From: [REDACTED]
Sent: 05 November 2012 13:19
To: Peter Cleveland
Subject: RE: 2 elm avenue

SHEET: PROPOSED PLANS/ELEVS.

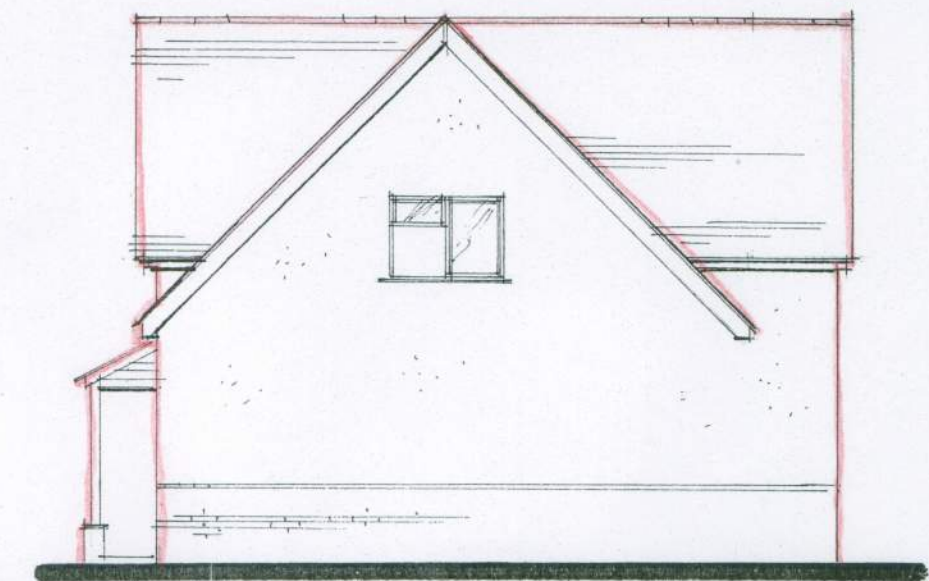
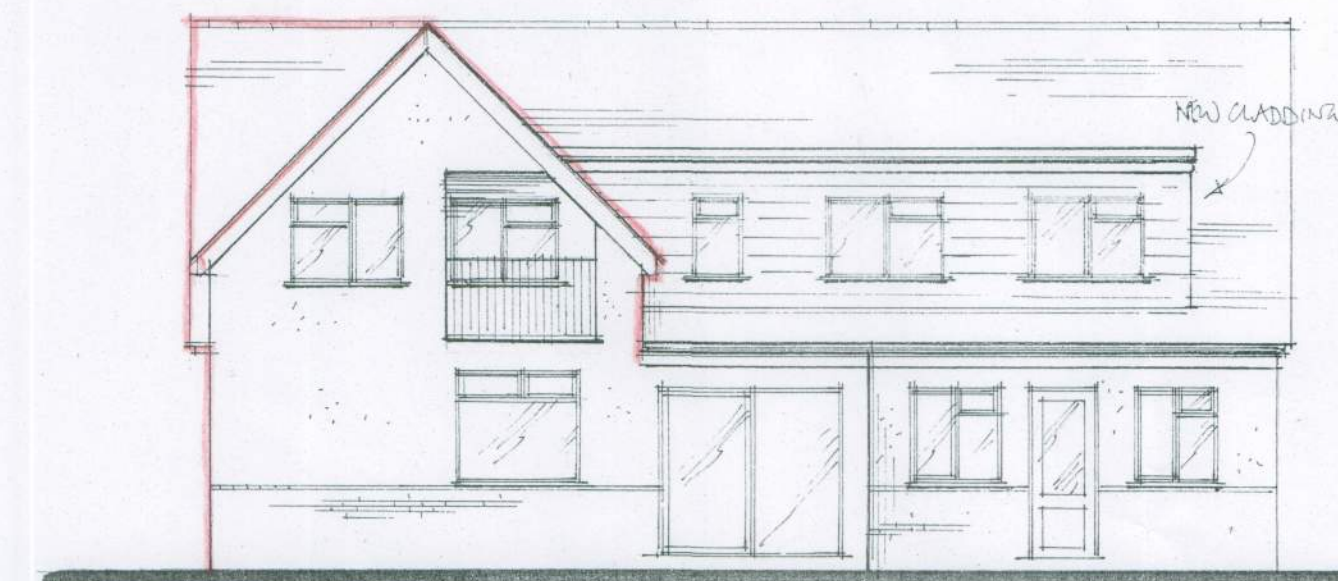
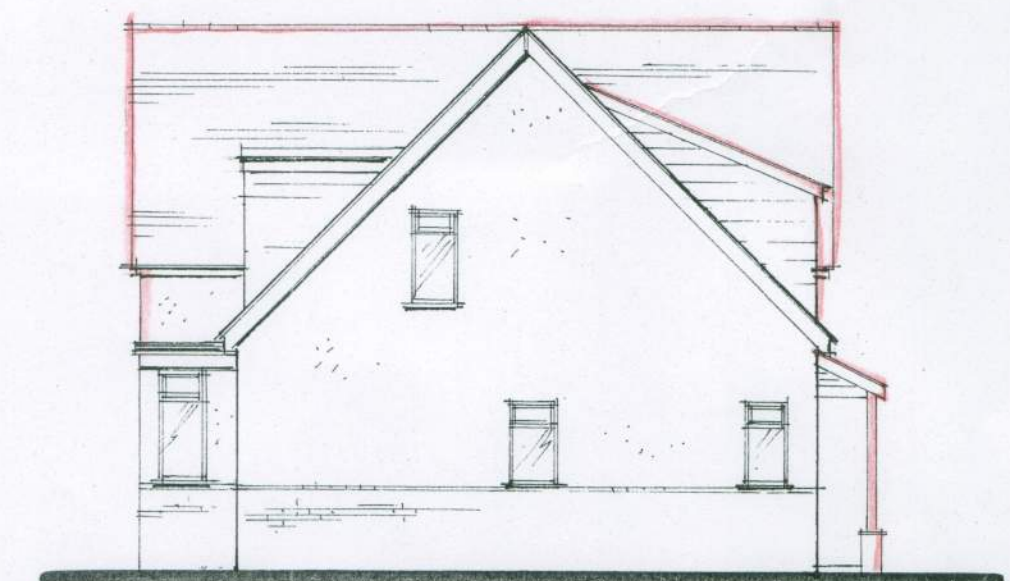
Materials to be changed to match the existing building and surrounding area.

Main gable and dormer gables therefore to be tile hung elevations.

PROPOSED NEW GARAGE
2 ELM AVENUE
EAST PRESTON

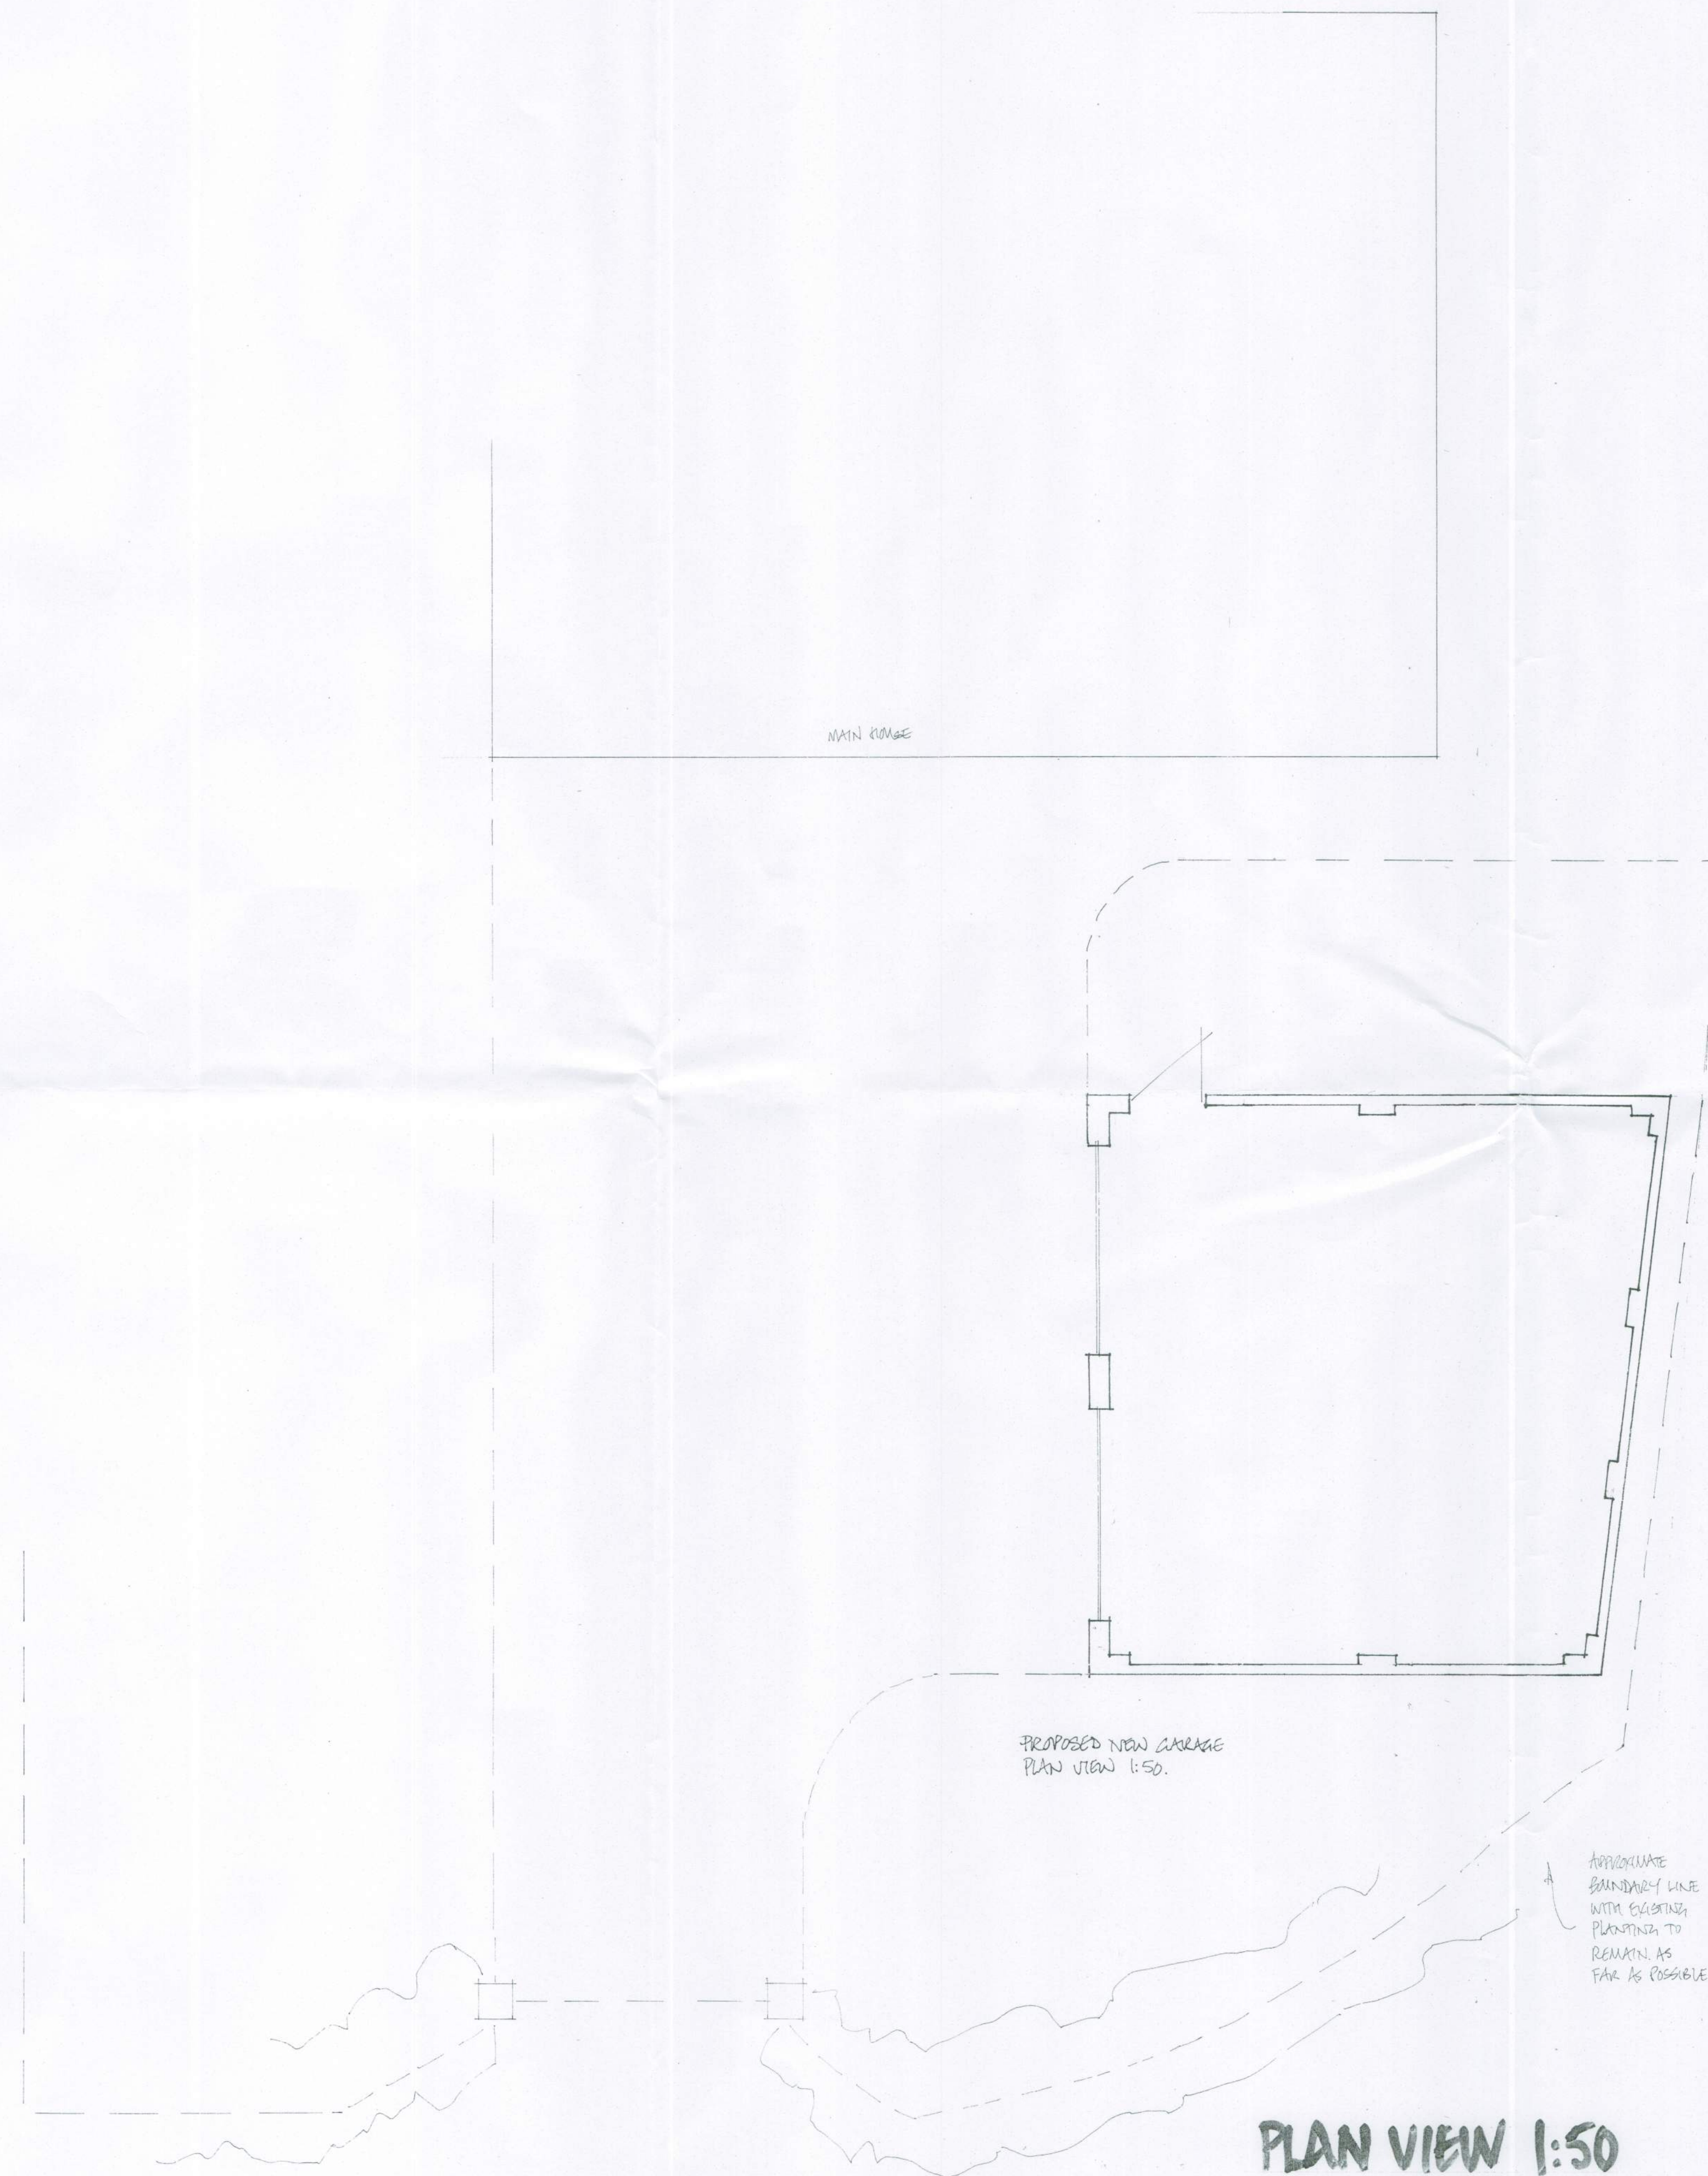
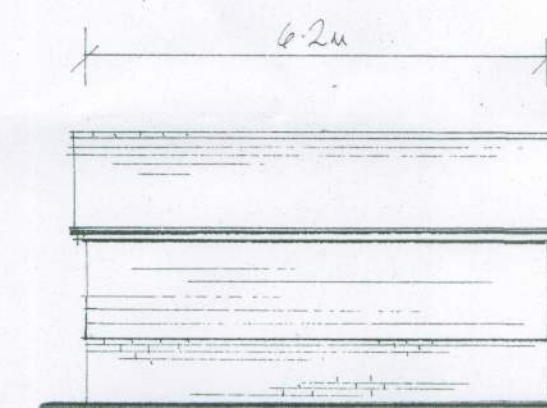
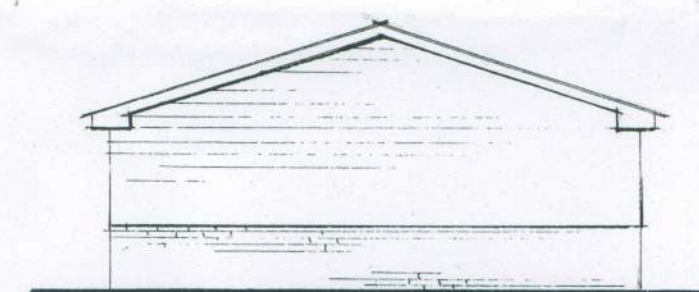
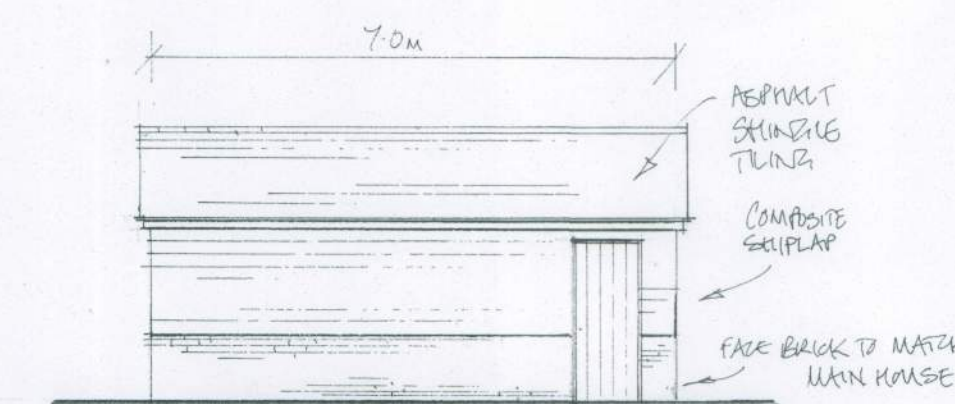
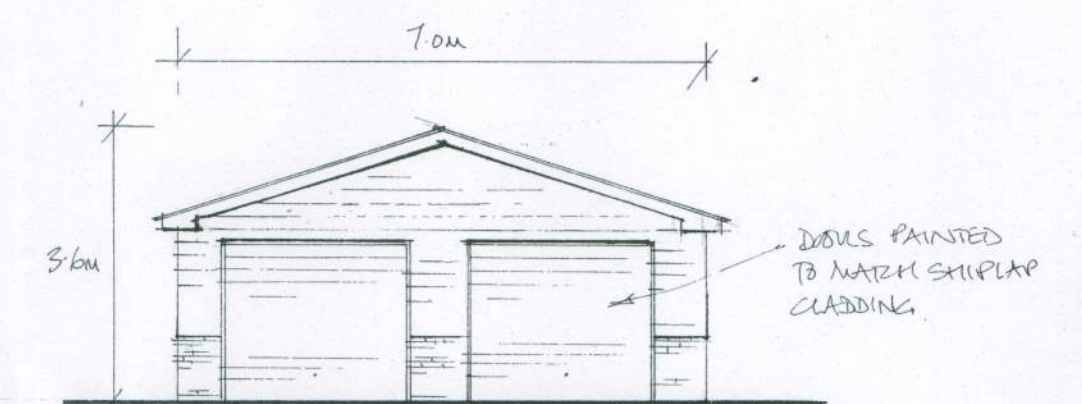
Thank you for the email. Please could you just respond to say that you would wish to withdraw the garage from the current application and I will amend the application details accordingly.

At this stage they would like to go with your advice and remove the garage from the application in order for the extension to go through without going to committee

We will re-submit an amended application for the garage in due course.
